OBJECTIONS TO PLANNING APPLICATION ALDWICK: AS/269/11.

OBJECTIONS TO PLANNING APPLICATION ALDWICK: AS/269/11.

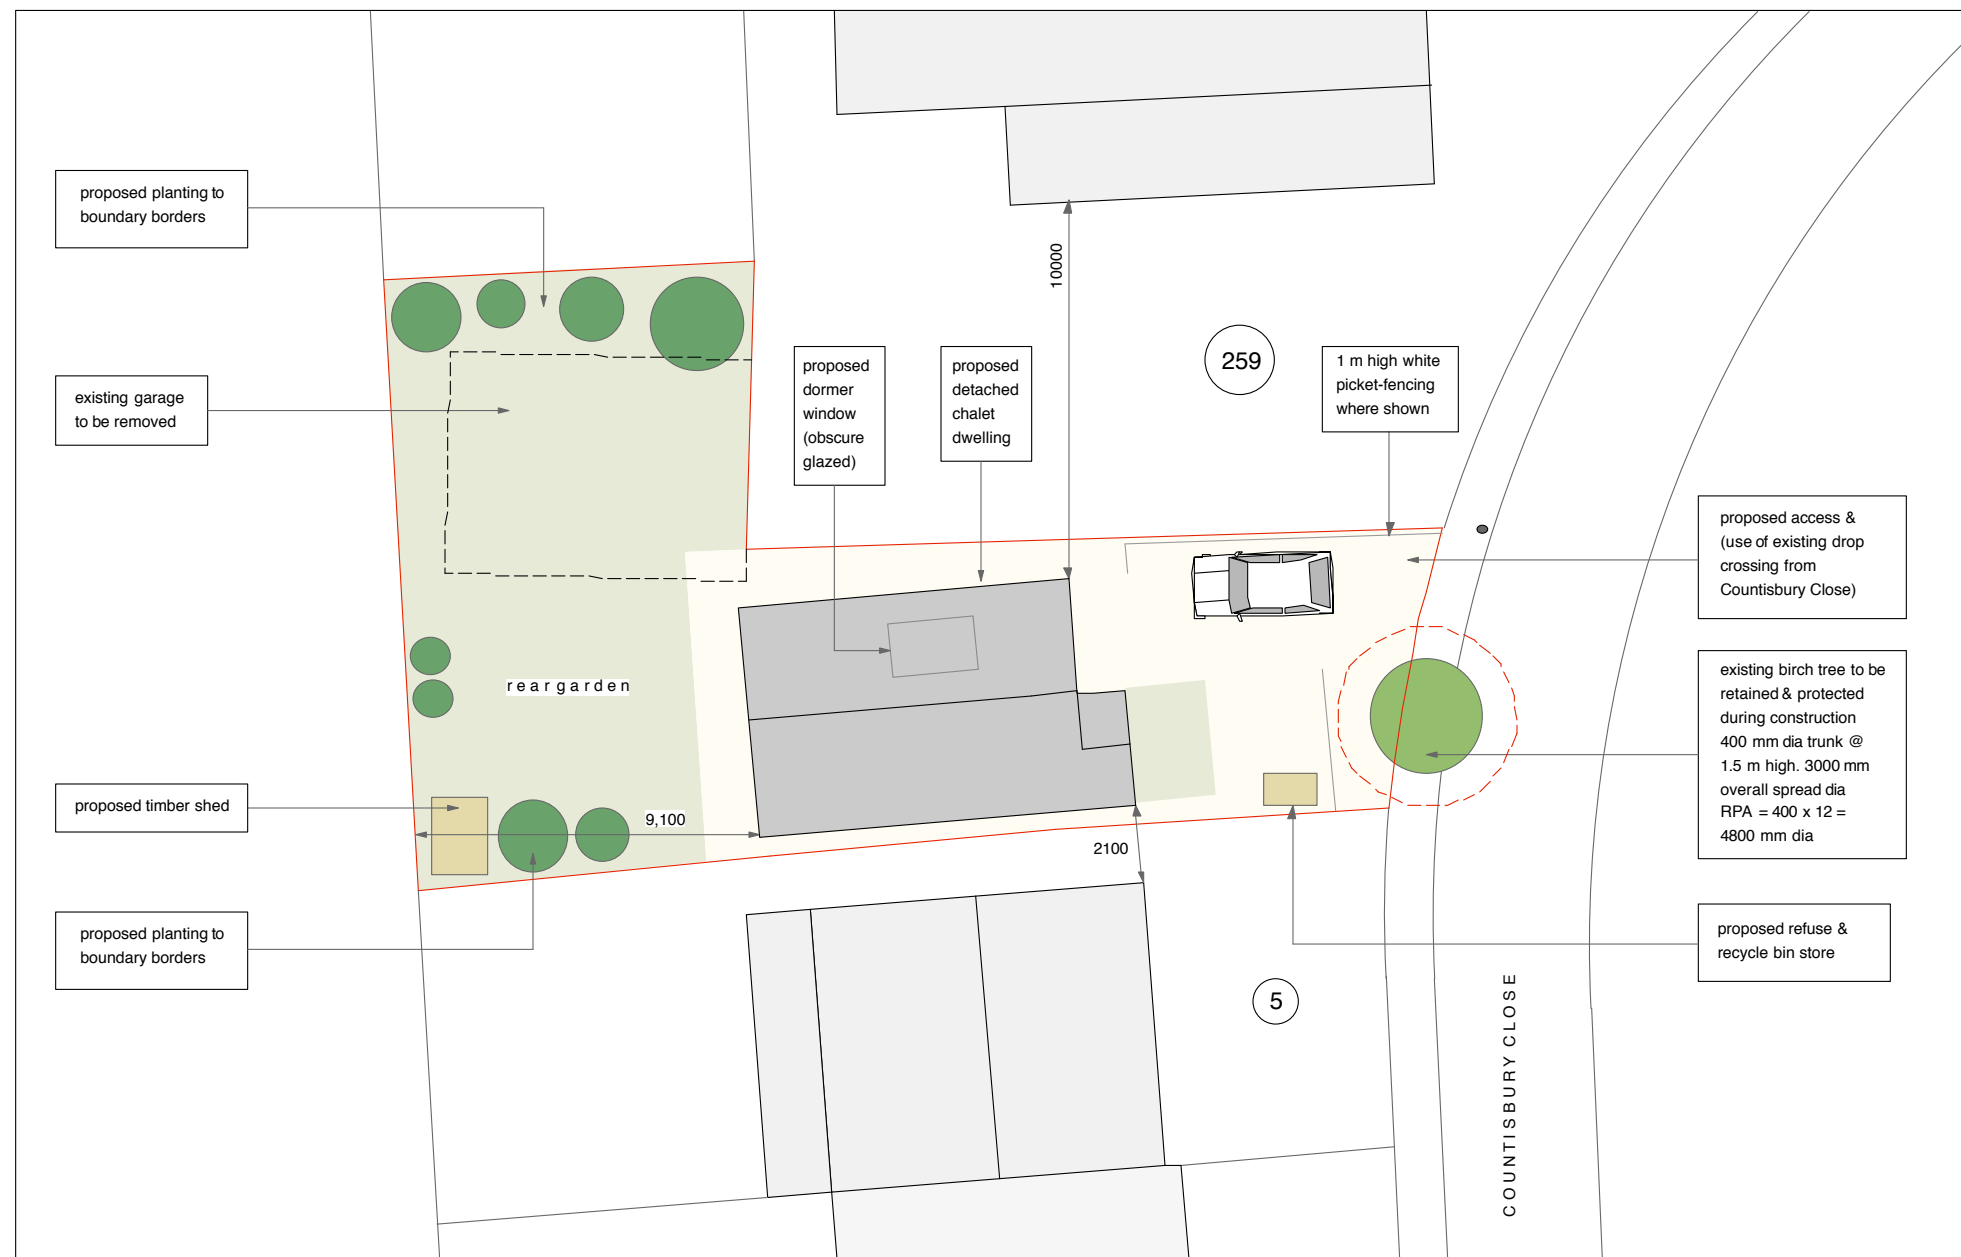
It should be noted that the plot entrance is on the apex of a 90 degree blind bend of a narrow road. Since the last application from the previous owner most of the houses within the Close have changed ownership. With the new owners bringing 2, 3, or 4 vehicles to a household and thus increasing the parking and traffic in this narrow road. We are lucky in only having had one serious accident but visiting vehicles still drive too fast around the bend. Due to the narrow plot there will be no room for on-site parking of delivery Lorries or skips should the development go ahead. Therefore these will have to be parked on the narrow road near or on the blind bend. The affect will be to block the narrow Countisbury Close road and increase the likelihood of further serious accidents. Access by the householders in and out of the close will significantly be affected and could even close the road.

Access to the narrow plot for building traffic, skips is limited by the space available, narrow road and location is on a blind bend to cause major problems of safety, noise and disruption to the access to Countisbury Close and its householders. As there are more properties on the wrong side of the plot means an increase in the passing traffic than when previous application submitted.

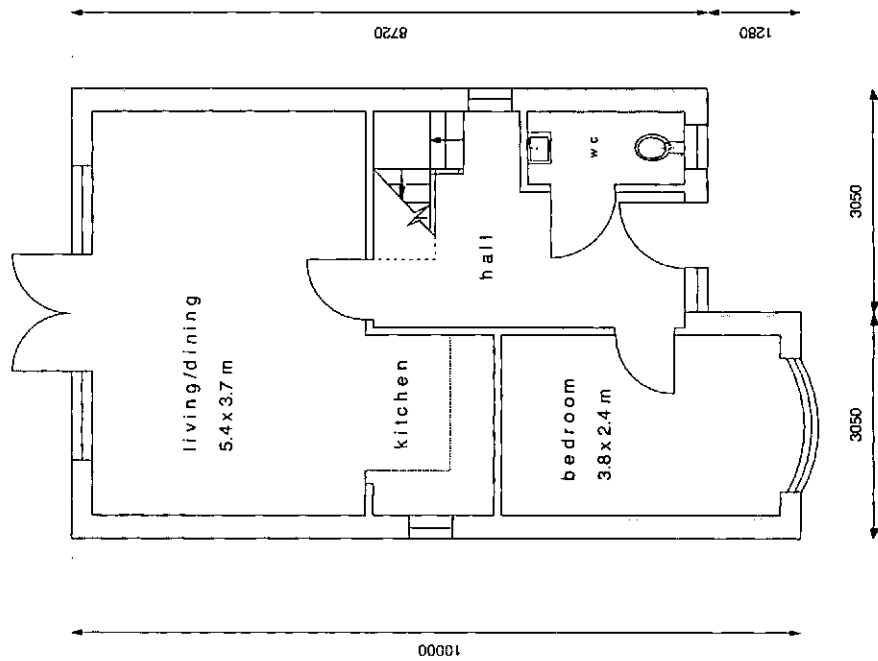
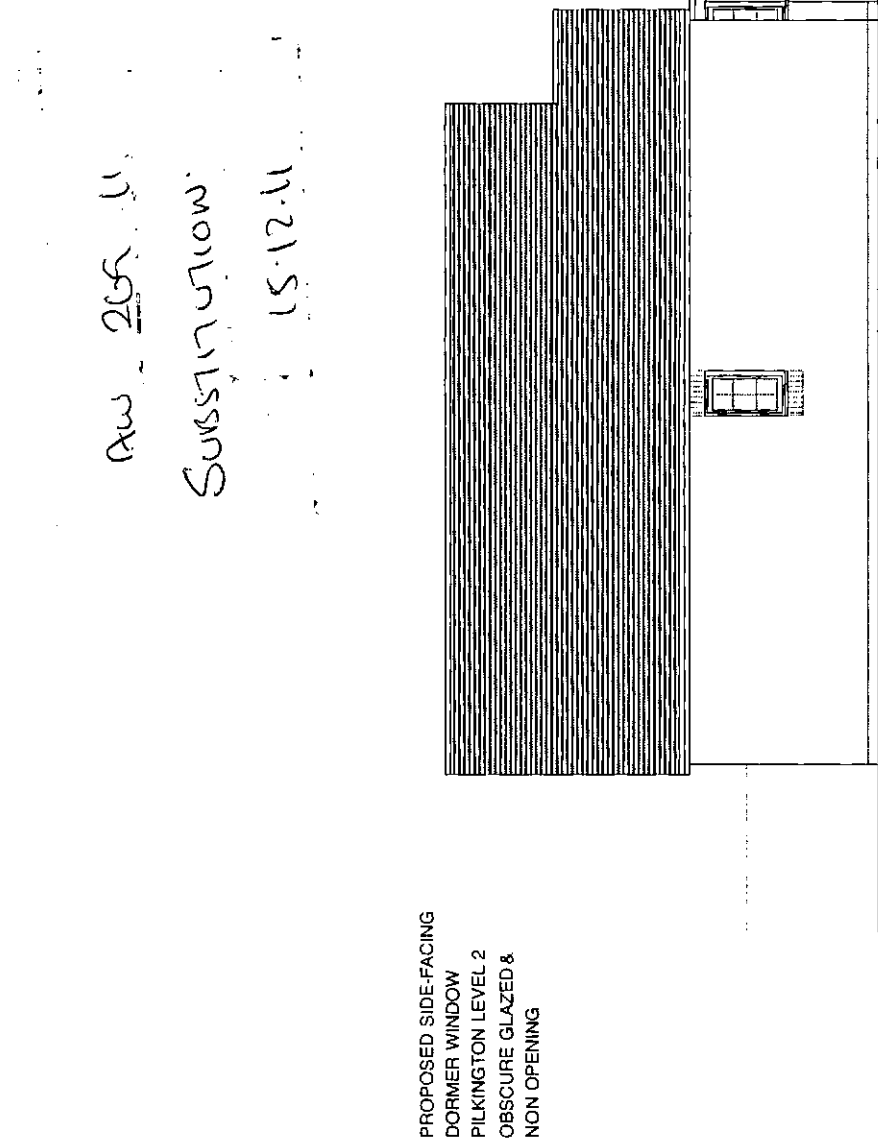
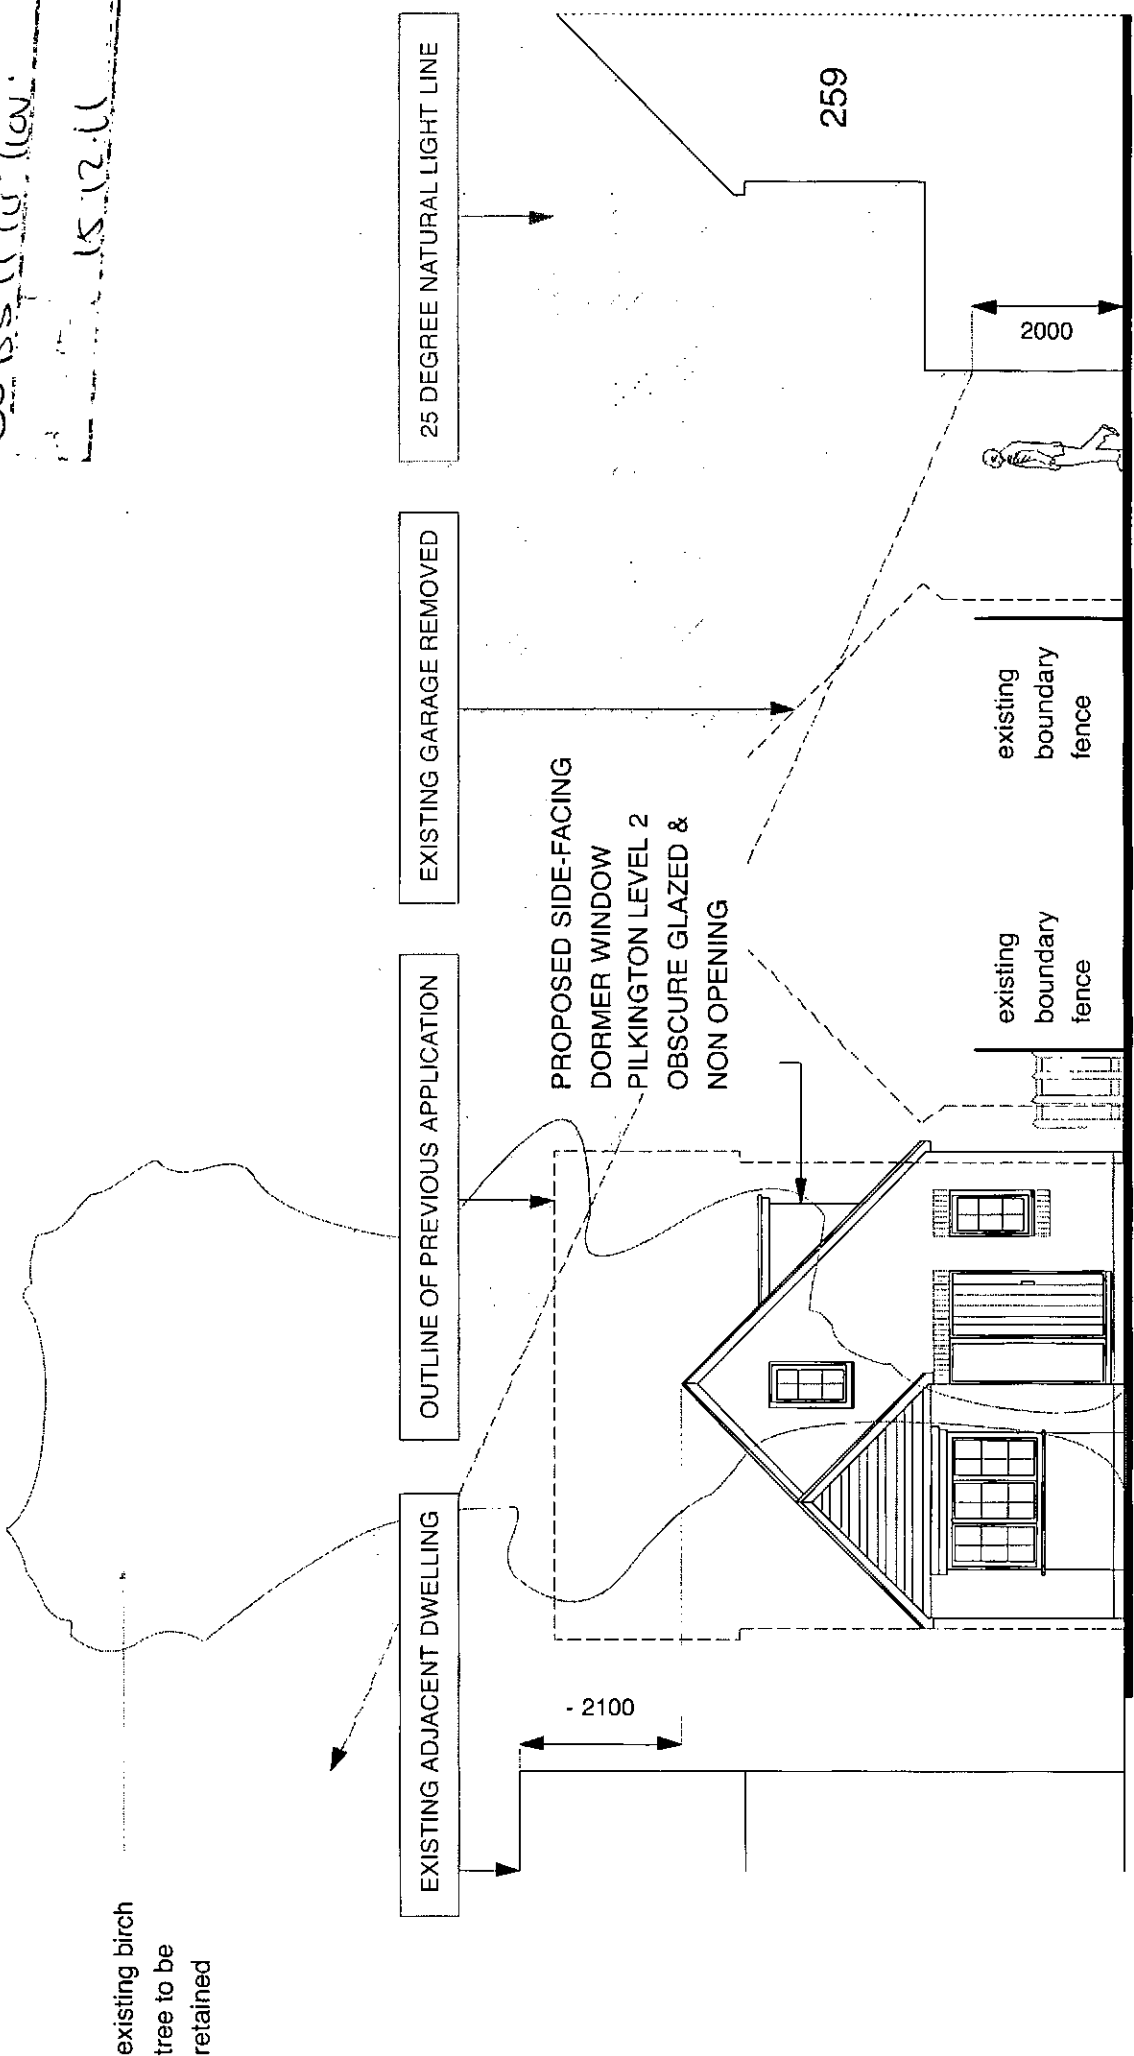
A chalet style property would not be in keeping with the rest of Countisbury Close properties that are all Georgian style houses, and would stick out like a sore thumb. There would be no benefit to the environmental or to the other occupants in the Close with this type of development, and is as with the previous owner strictly a speculative application.

Any development on this plot beyond the present garages shall still affect the light available to the side (north facing) and back windows (west facing). Since around 1990 I have displayed and claimed the rights of Ancient Lights by displaying of a notice by these windows. This has been recorded in every one of my objection letters since then. Any development would infringe my rights of removing establish daylight rights to my property.

I have claimed Ancient Lights rights since 1990's as recorded in my objects to all of the previous series of planning application for the main source of daylight to the working area of our kitchen. Any increase in the structure of any dwelling replacing the garages shall impact the present light levels.

A chalet style property would not be in keeping with the rest of Countisbury Close properties that are all Georgian style houses, and would stick out like a sore thumb.
